NSW RURAL FIRE SERVICE

Your reference: SSD 9741
Our reference: D18/8341

Lane Cove West Data Centre (SSD 9741) at 1 Sirius Road Lane Cove West

Project Status	SSD	
Drawing Title	MASTER PLAN - EGRESS DIAGRAM	
Drawing Number	ATSYD2_SSD_DRG_ARC_0900

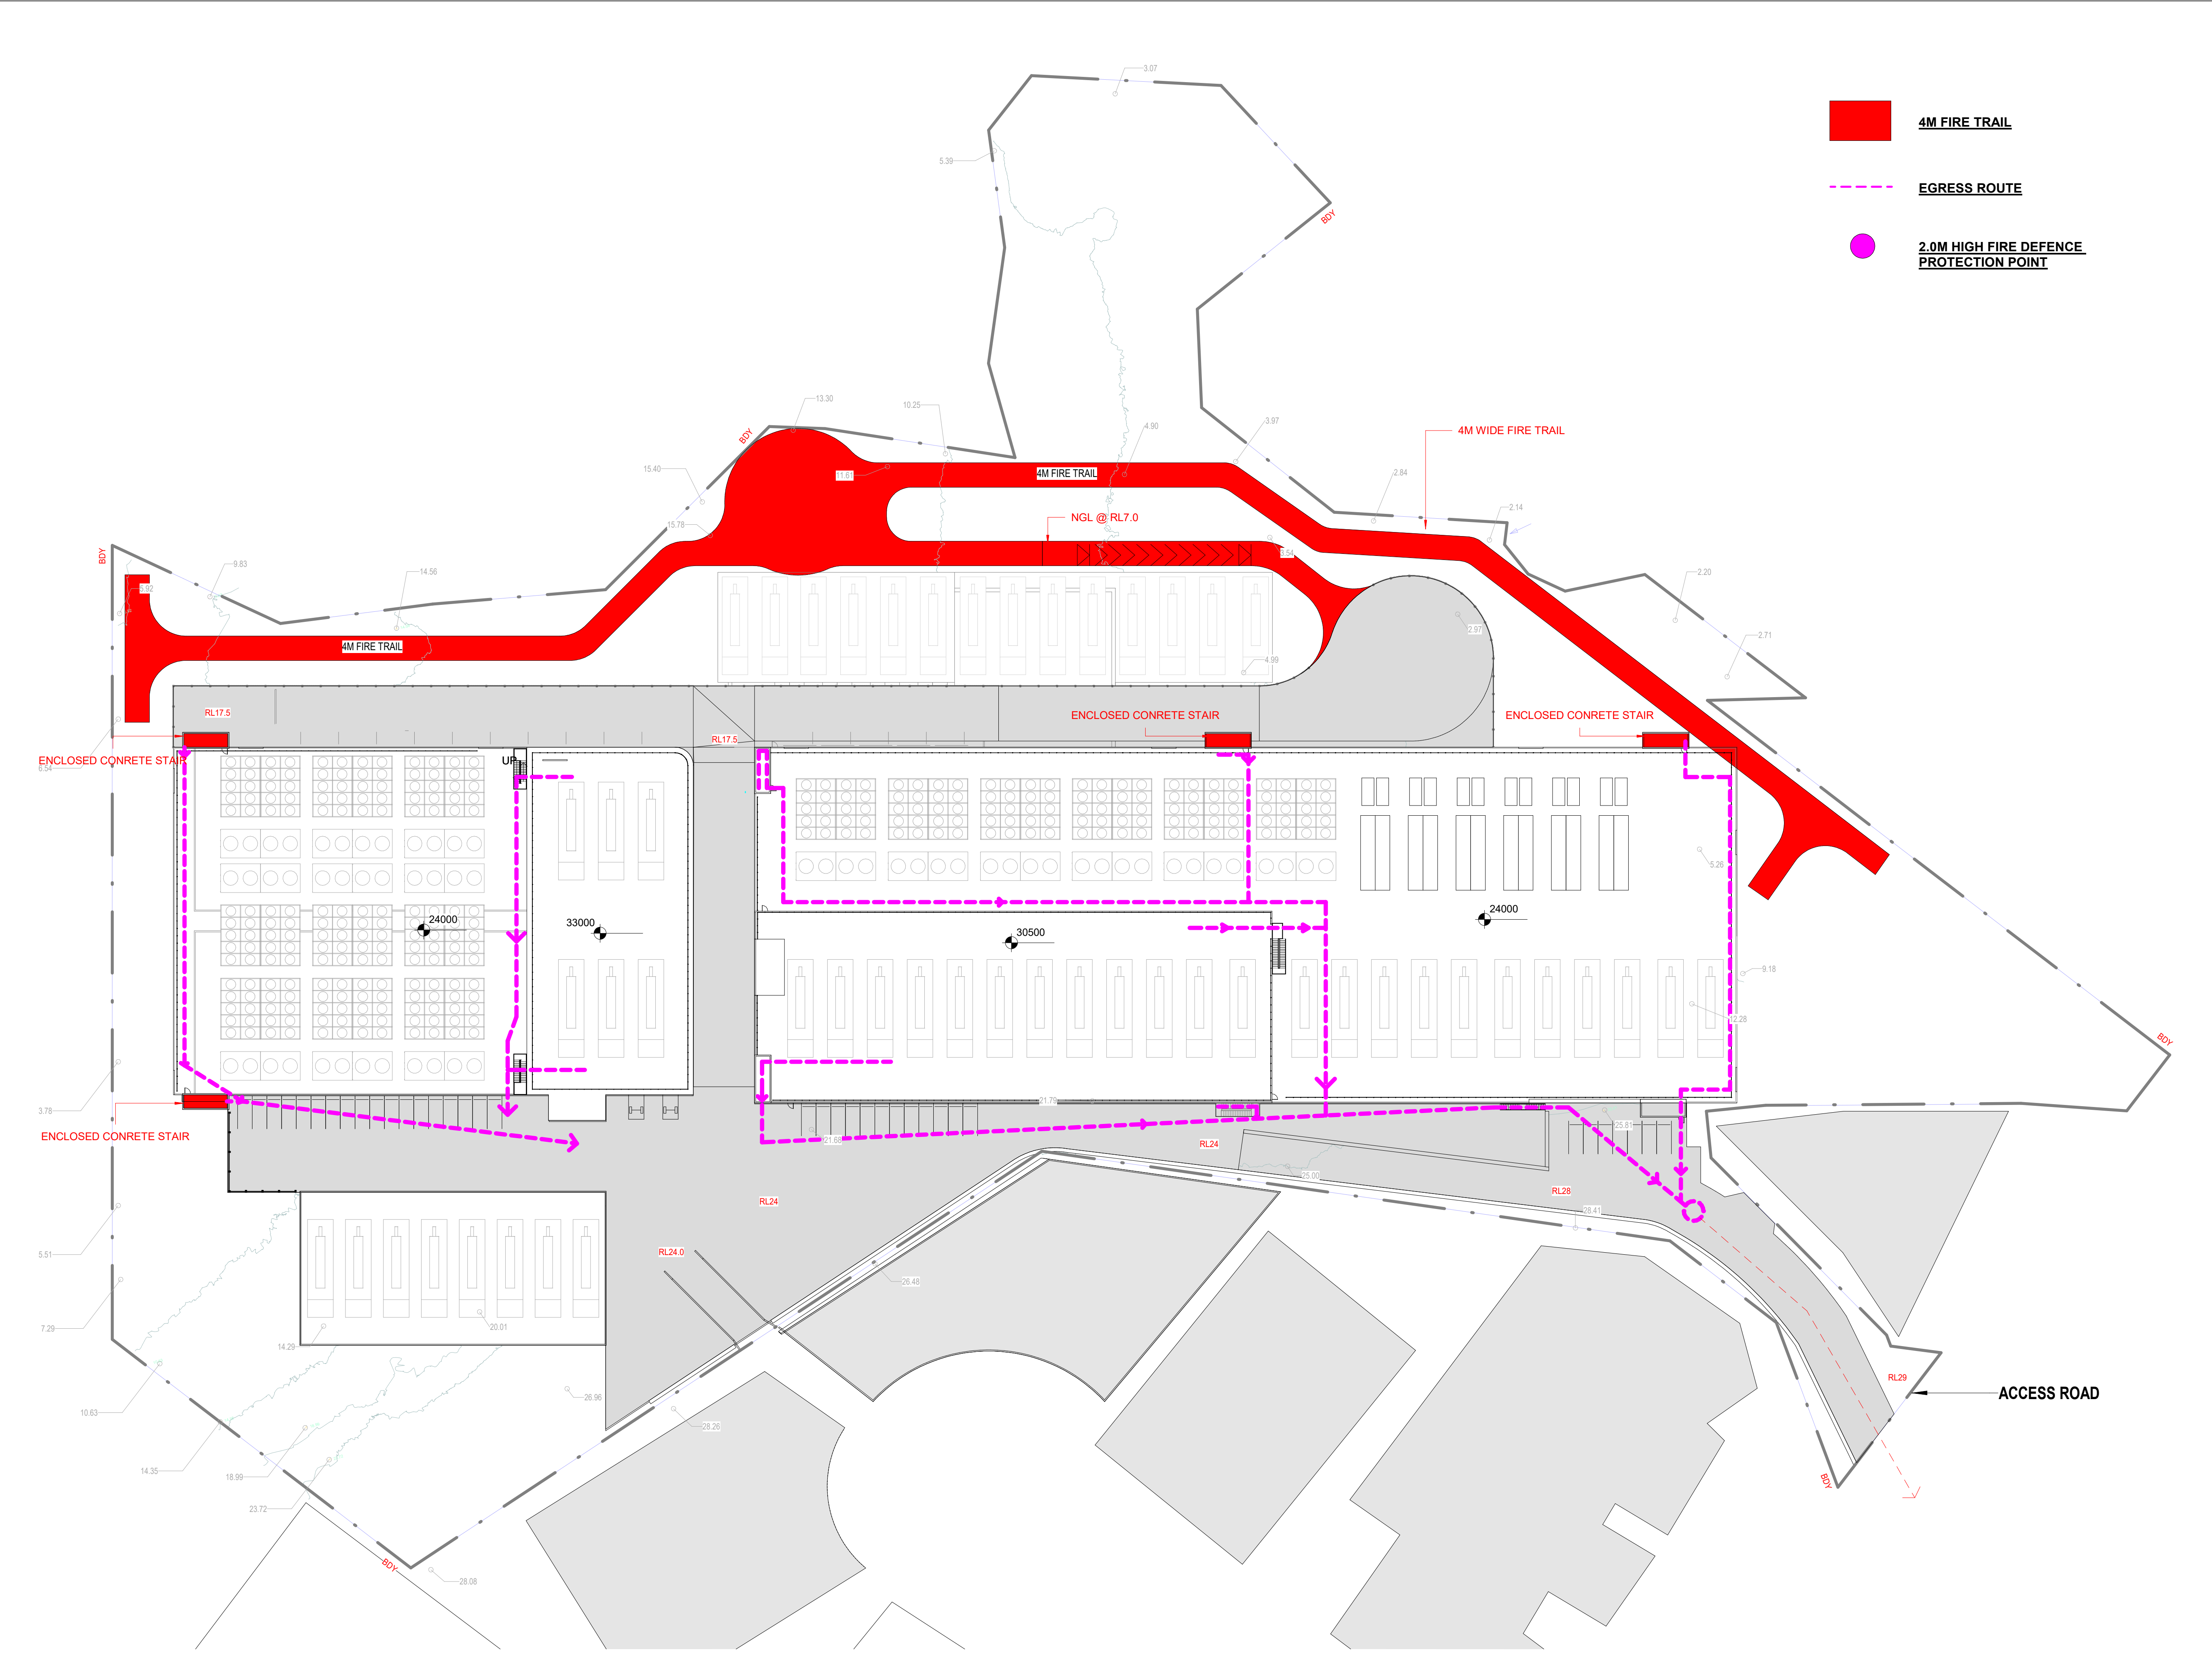
The intent of measures for fire trails is to provide suitable access for fire management purposes and maintenance of APZs. To achieve this, the following conditions shall apply:

4. Fire trails shall comply with section 4.1.3 (3) of *Planning for Bush Fire Protection 2006*.
